From: [REDACTED]
Sent: 11 October 2021 17:13
To: Simon Davis
Cc: Christopher Best; 'richard'; 'Joe'; 'Tim Button'; 'Chris Southcott'
Subject: RE: Springfield, Hook Lane ref AL/112/21/DOC
Attachments: (435050) Springfields, Aldingbourne - SW Network Calculations (Surcharge....pdf; 435050 - SuDS Maintenance and Management Plan (OCT 2021 REV).pdf; 435050-202P5 (DRAINAGE LAYOUT 2 OF 2).pdf; 435050-203P4 (DRAINAGE DETAILS 1 OF 2).pdf

Subject: RE: Springfield, Hook Lane ref AL/112/21/DOC

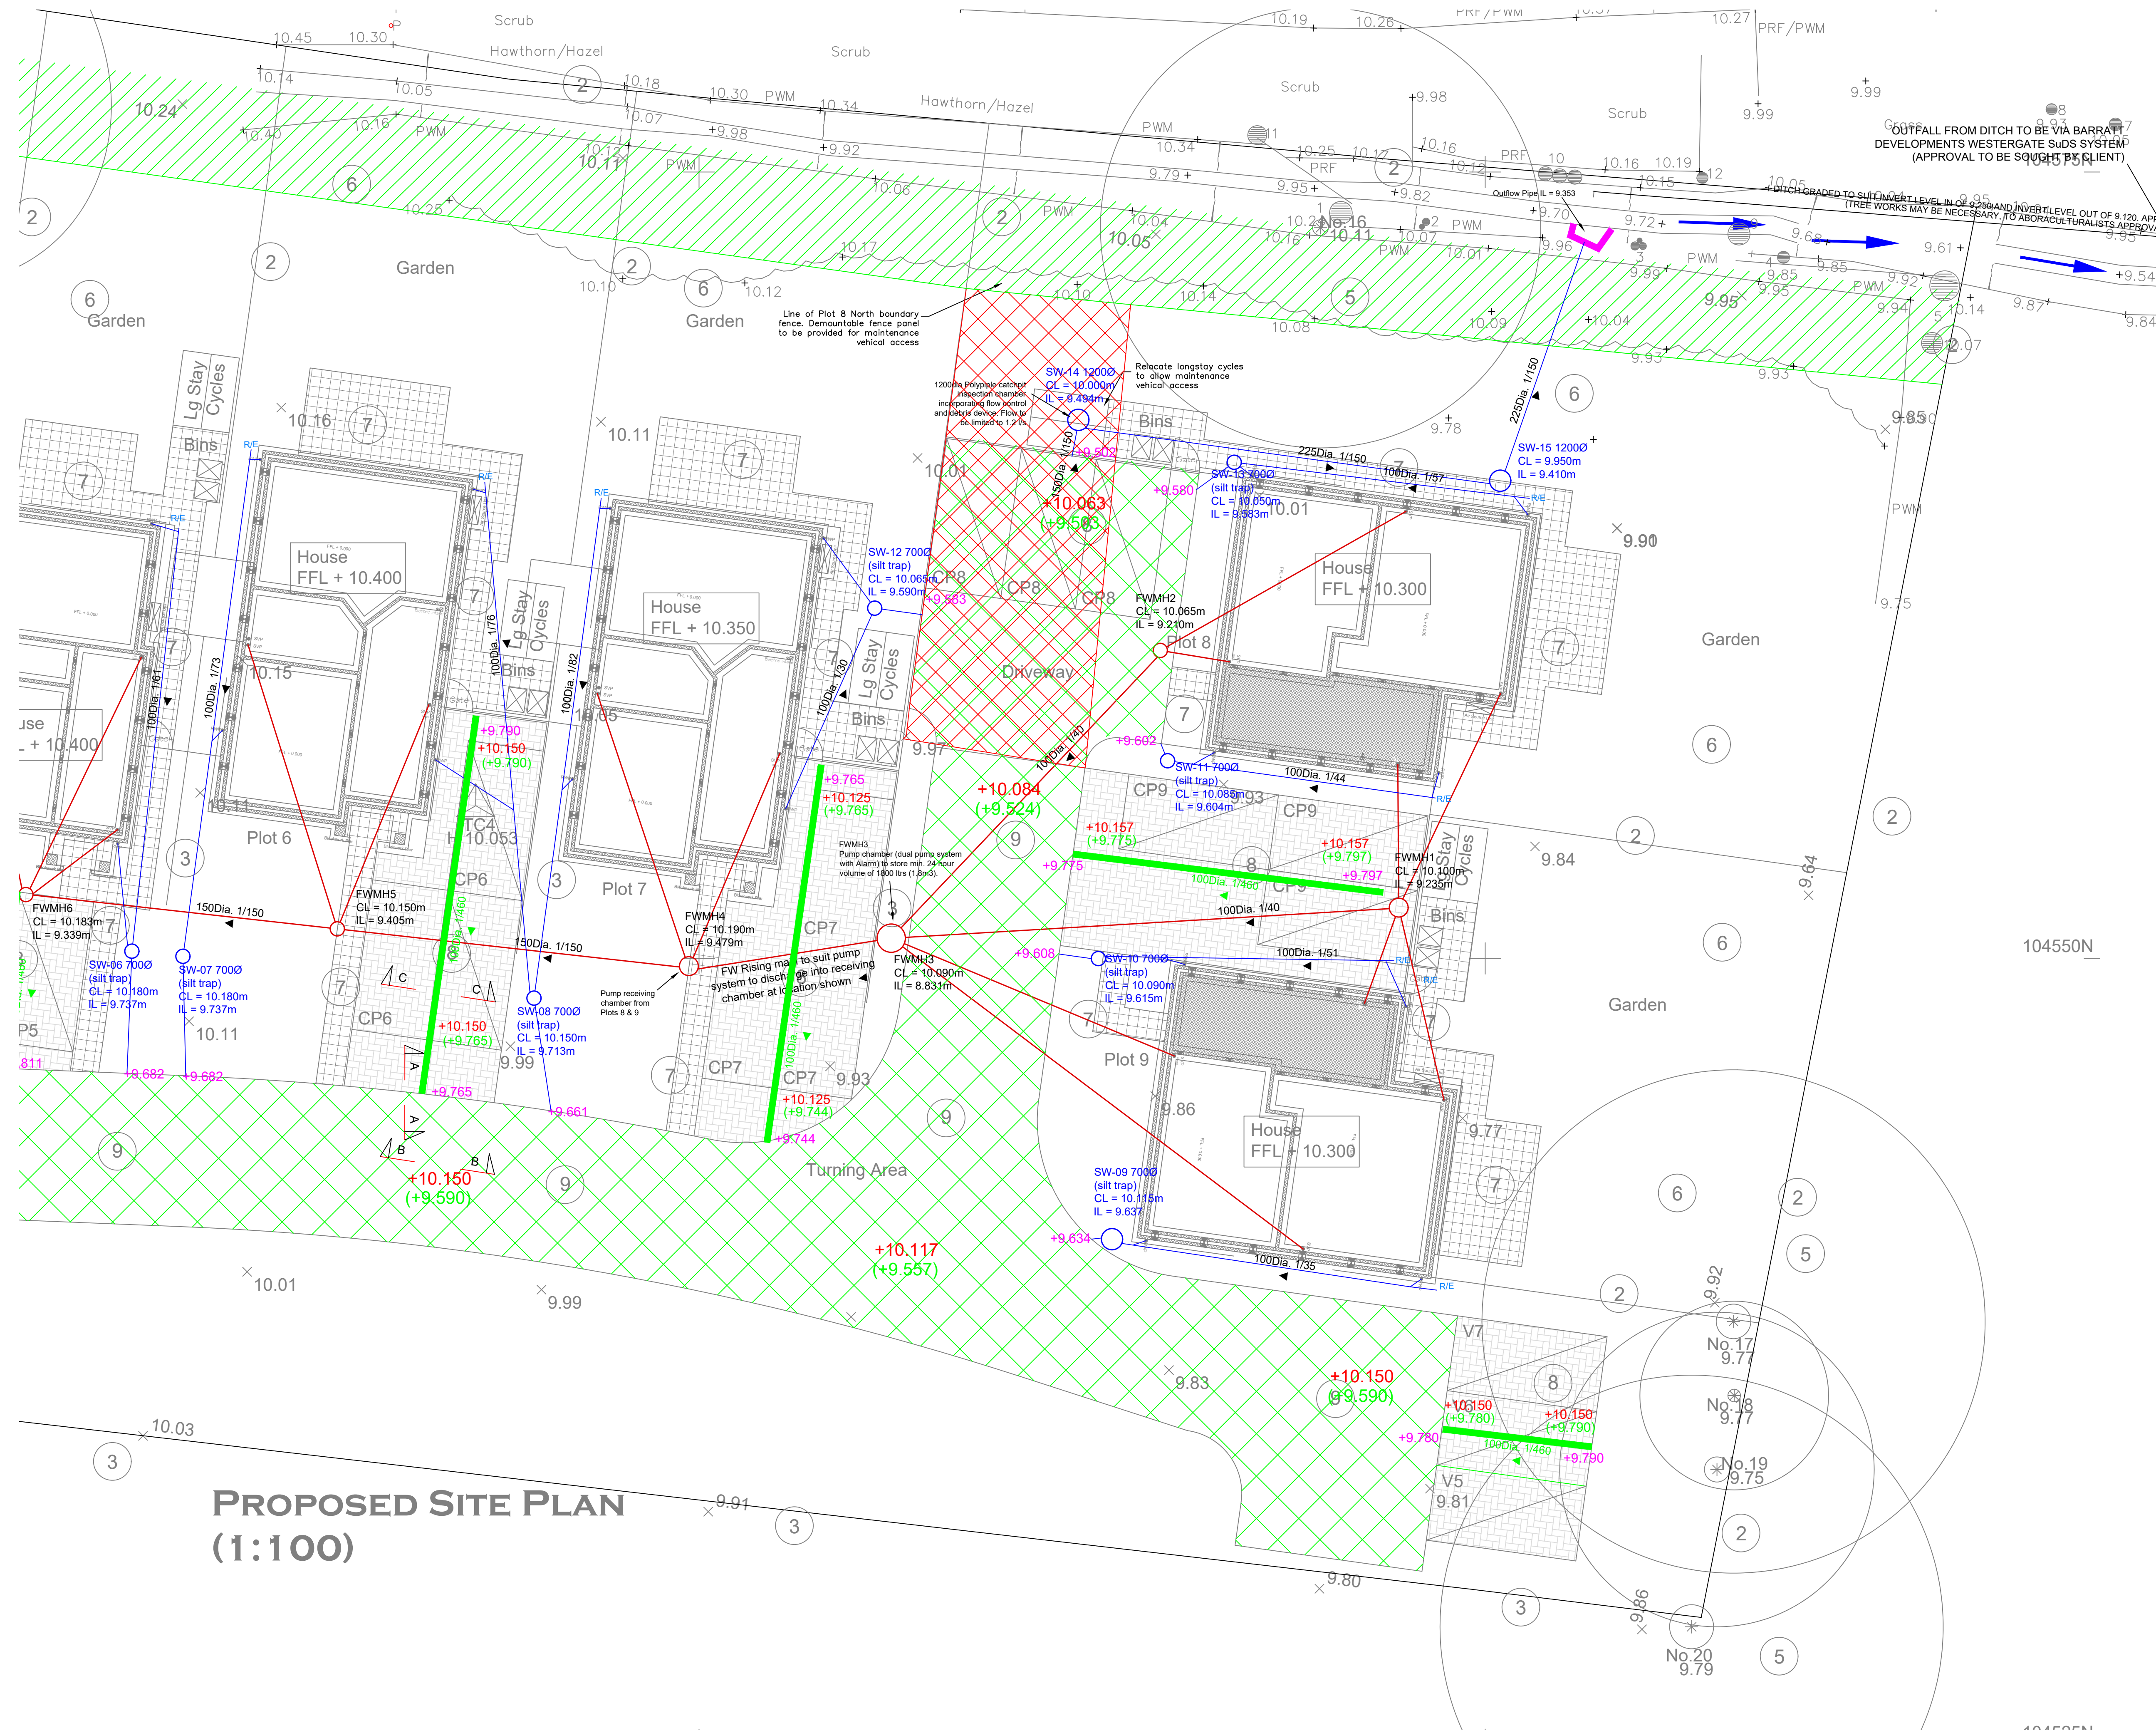
1. Calculations have now been submitted, however these do not include a surcharged outfall as requested previously (point 2 in response of 14th September). A surcharged outfall must be modelled with water level set to the top of bank of watercourse level.
2. Winter groundwater monitoring for the period 30/01/21 to 13/03/21 has been supplied. As have flotation calculations. These show the design to be adequate, even if groundwater rose slightly above that recorded.
3. The unit reference of the hydrobrake must be referenced on both the construction detail drawing and layout. Hydrobrake reference number must be consistent with calculations.

1. Calculations have now been submitted, however these do not include a surcharged outfall as requested previously (point 2 in response of 14th September). A surcharged outfall must be modelled with water level set to the top of bank of watercourse level. **Calculations attached.**
2. Winter groundwater monitoring for the period 30/01/21 to 13/03/21 has been supplied. As have flotation calculations. These show the design to be adequate, even if groundwater rose slightly above that recorded.
3. The unit reference of the hydrobrake must be referenced on both the construction detail drawing and layout. Hydrobrake reference number must be consistent with calculations. **Updated on drawings 435050-202P5 & 435050-203P4**
